RE: Kittitas Public Utility District #1 Headquarters SEPA Application (SE-26-00003)

Kittitas PUD truly values the opportunity for public engagement and would like to thank the County and community members who took the time to review the project and provide thoughtful feedback. This document represents the District's response to those comments.

OVERALL SITE PLAN

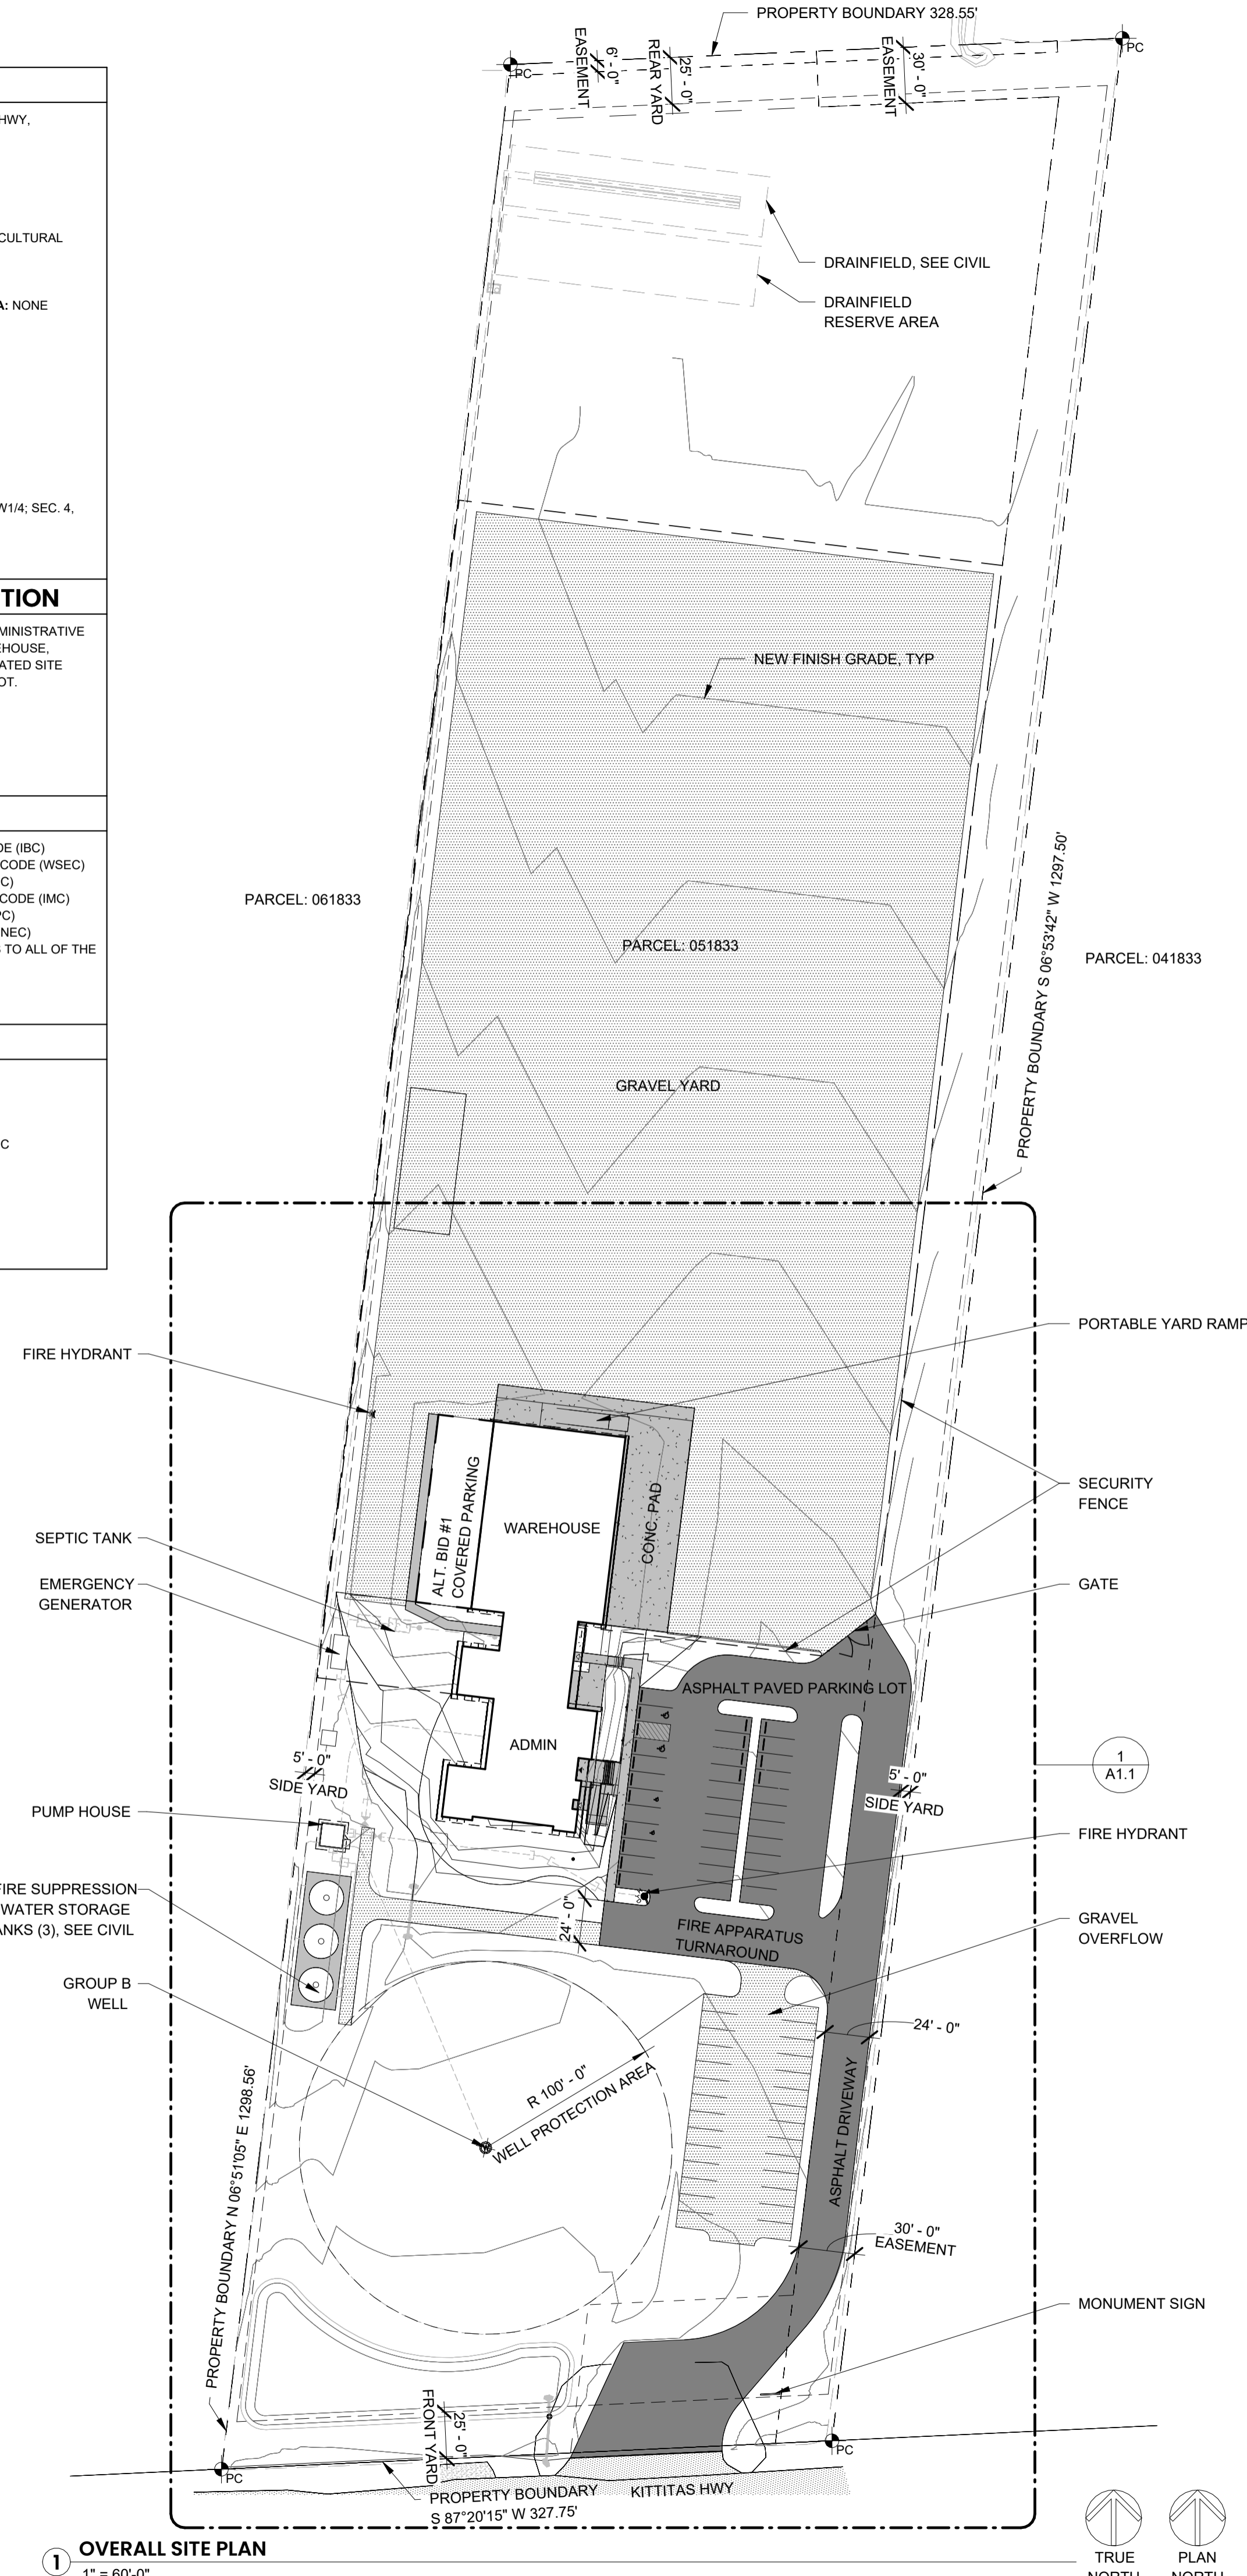
Comments related to surface water have been reviewed. The District is aware of the drainage ditch located within the public right-of-way along the south edge of the site. A topographic survey obtained by the PUD in May 2025 indicates a depression along the east property line, which the Cascade Irrigation District has confirmed is not used to convey irrigation water. Neither feature is considered "Surface Water" for the purposes of SEPA determinations. There are no wetlands or streams identified on the subject parcel. Two wetlands identified on the Kittitas County COMPAS exist more than 380 feet away from the PUD-owned parcel, exceeding the 250 foot distance requirement for consideration in the SEPA process.

Site lighting for the storage yard will be off after business hours and will only be lit by motion sensors when staff are present in the event of outages and or other required off-hours operational activities. In addition, the light poles will be fixtures with sharp cut off optics. This means all exterior fixtures direct the light down with no light going up. Though not a County requirement, the PUD will comply with Ellensburg ordinances and dark sky best practices. The parking lot and exterior building lights will be set to 20% capacity after business hours, and only fully illuminated with motion sensors when people are present for safety and security.

There are no landscaping or open space requirements for AG-20 zoning; any references to landscape buffering in the Conditional Use Permit process do not apply as this project is a permitted use that does not require a CUP application. However, KPUD is voluntarily landscaping the frontage along Kittitas Highway and portions of the property boundary abutting the neighboring residences.
